WEST SUSSEX COUNTY COUNCIL CONSULTATION

TO:	Arun District Council FAO:Anita Gardner
FROM:	WSCC - Highways Authority
DATE:	2 February 2022
LOCATION:	Old Bank House 3 High Street Arundel BN18 9AD
SUBJECT:	AB/1/22/DOC Approval of details reserved by condition imposed under AB/122/20/PD relating to condition 1-covered and secure cycle parking spaces.
DATE OF SITE VISIT:	n/a
RECOMMENDATION:	Advice
S106 CONTRIBUTION TOTAL:	n/a

**PROPOSED BASEMENT  
FLOOR PLAN  
(1:50)**

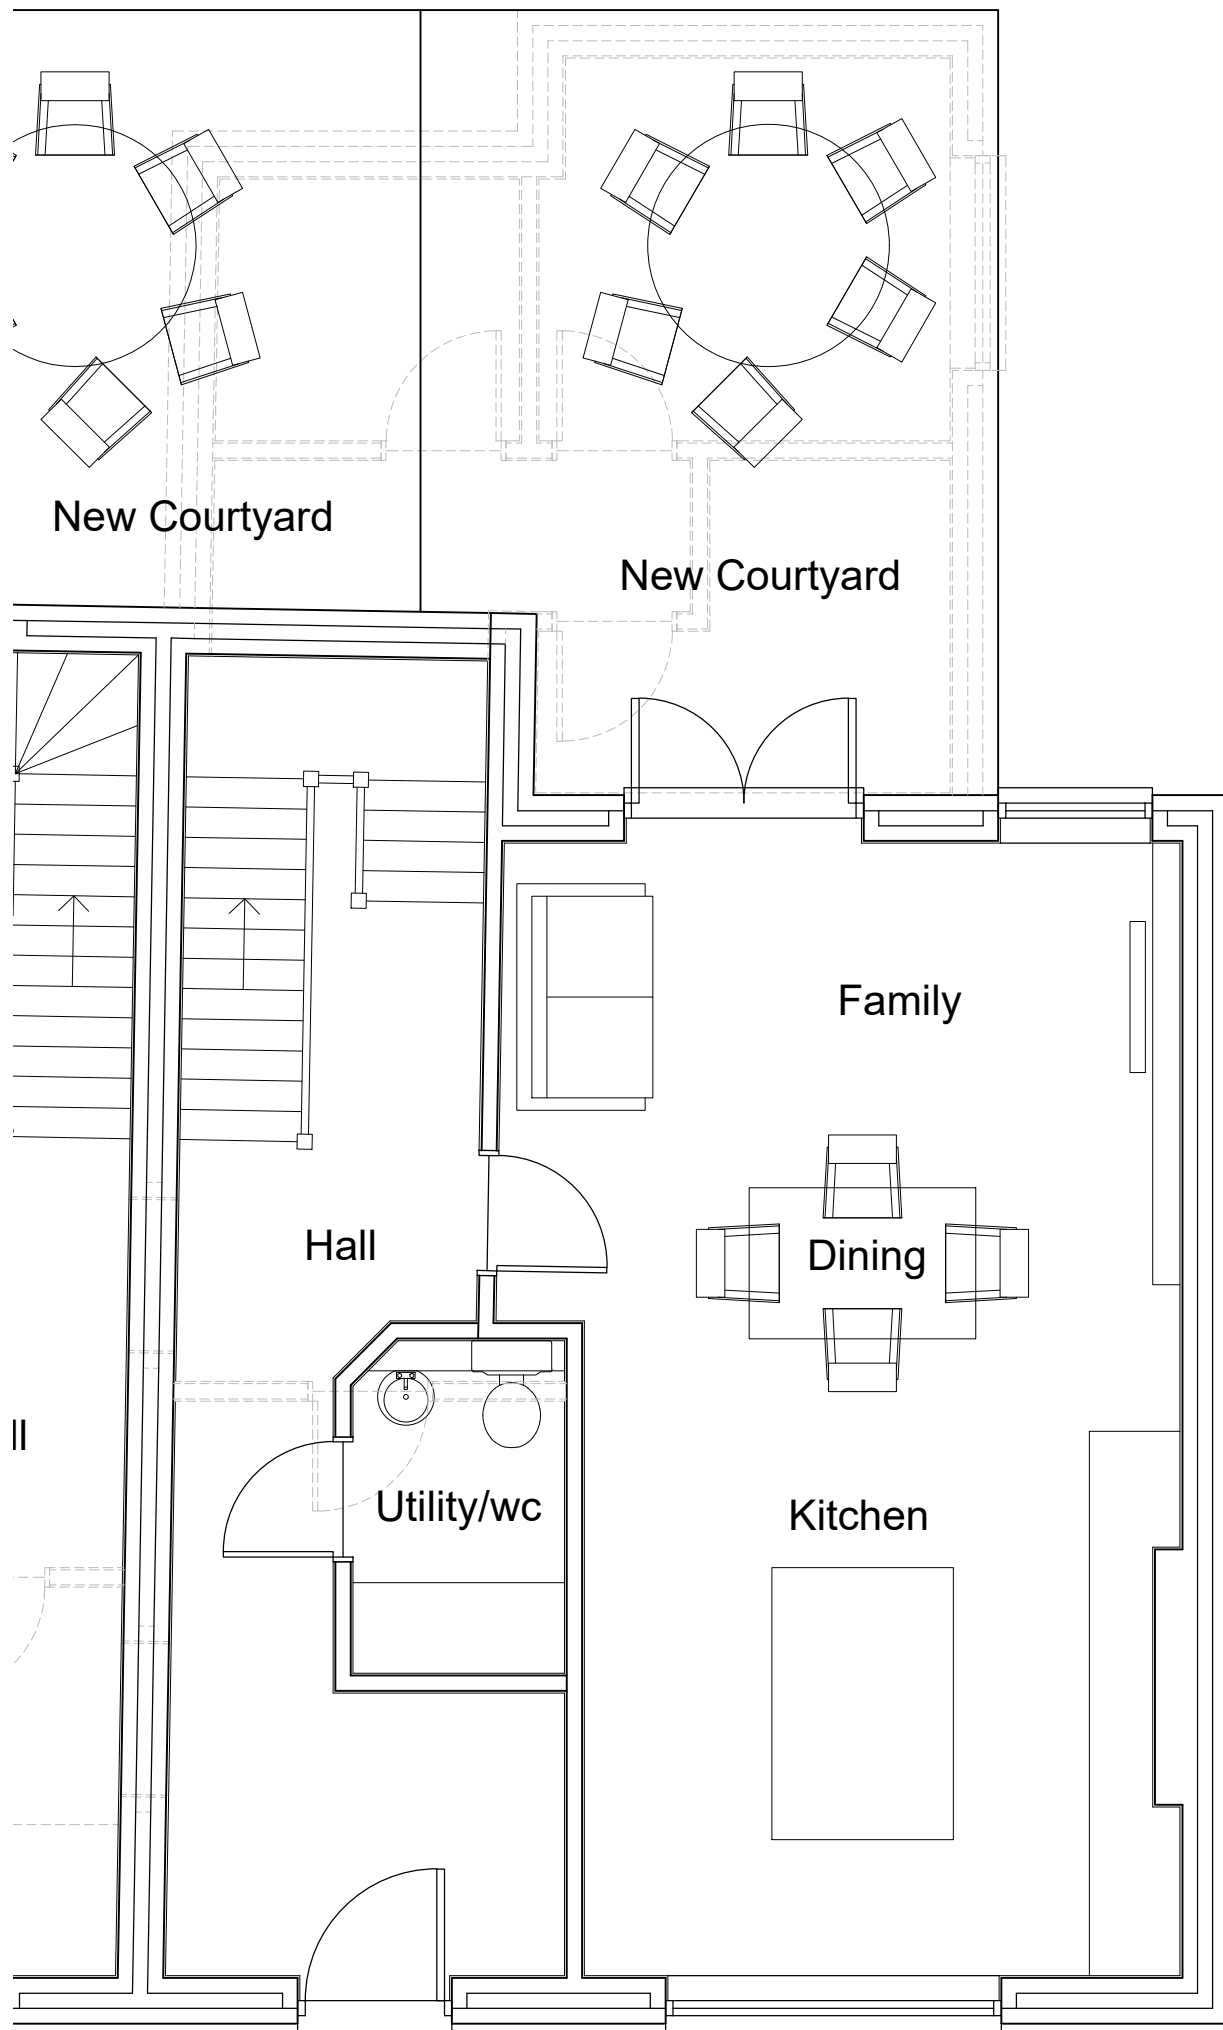
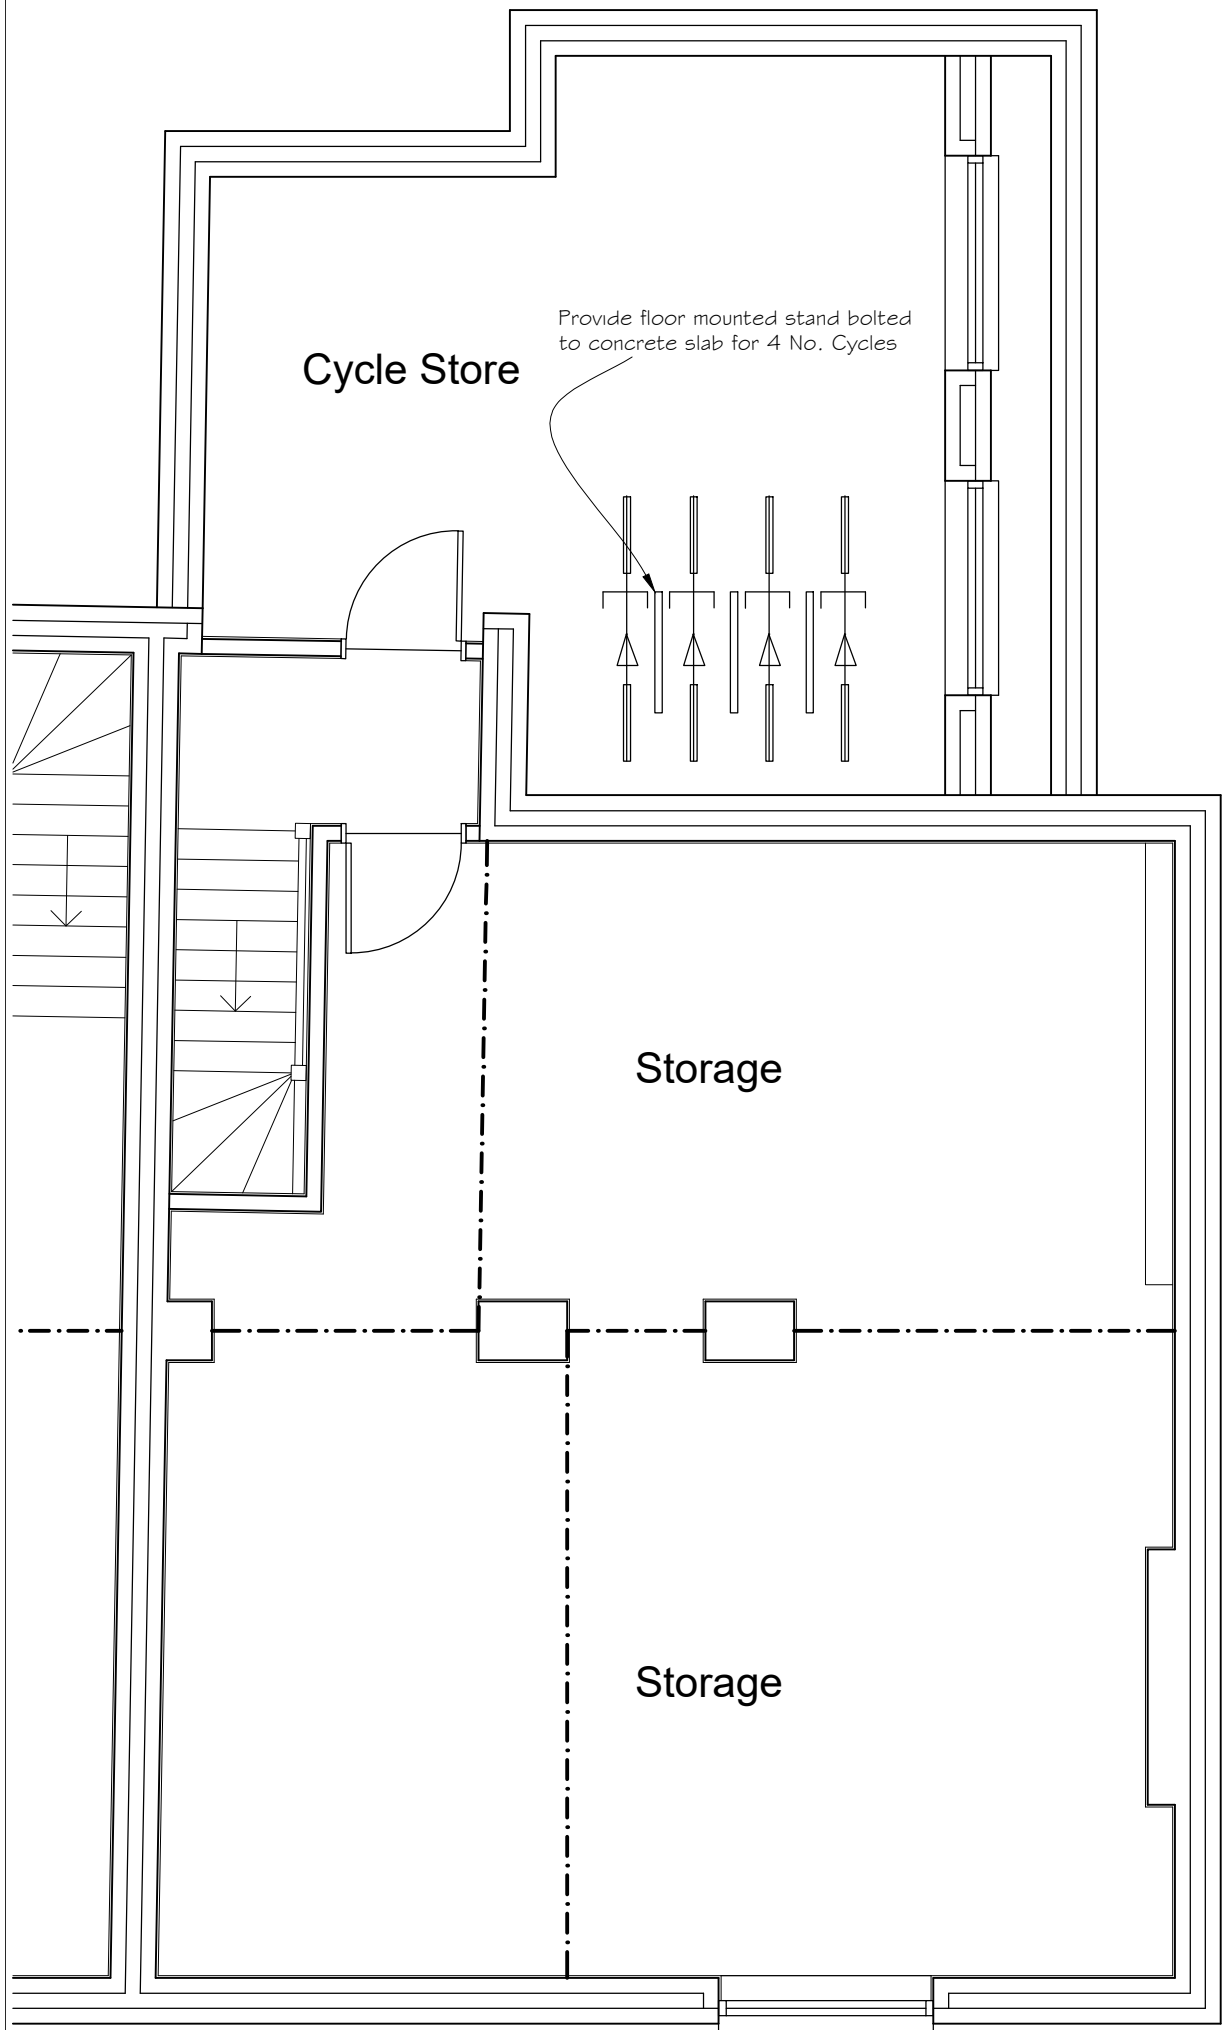
The applicant has demonstrated that the Cycle Parking will be located within the basement of the property. While this would not be considered an ideal practice, weight must be given to the property type and location. The LHA are also minded that individuals that use cycles for their work commutes are less likely to be deterred by such a location compared to a causal user.

The LHA raise no concerns over the discharge of this condition.
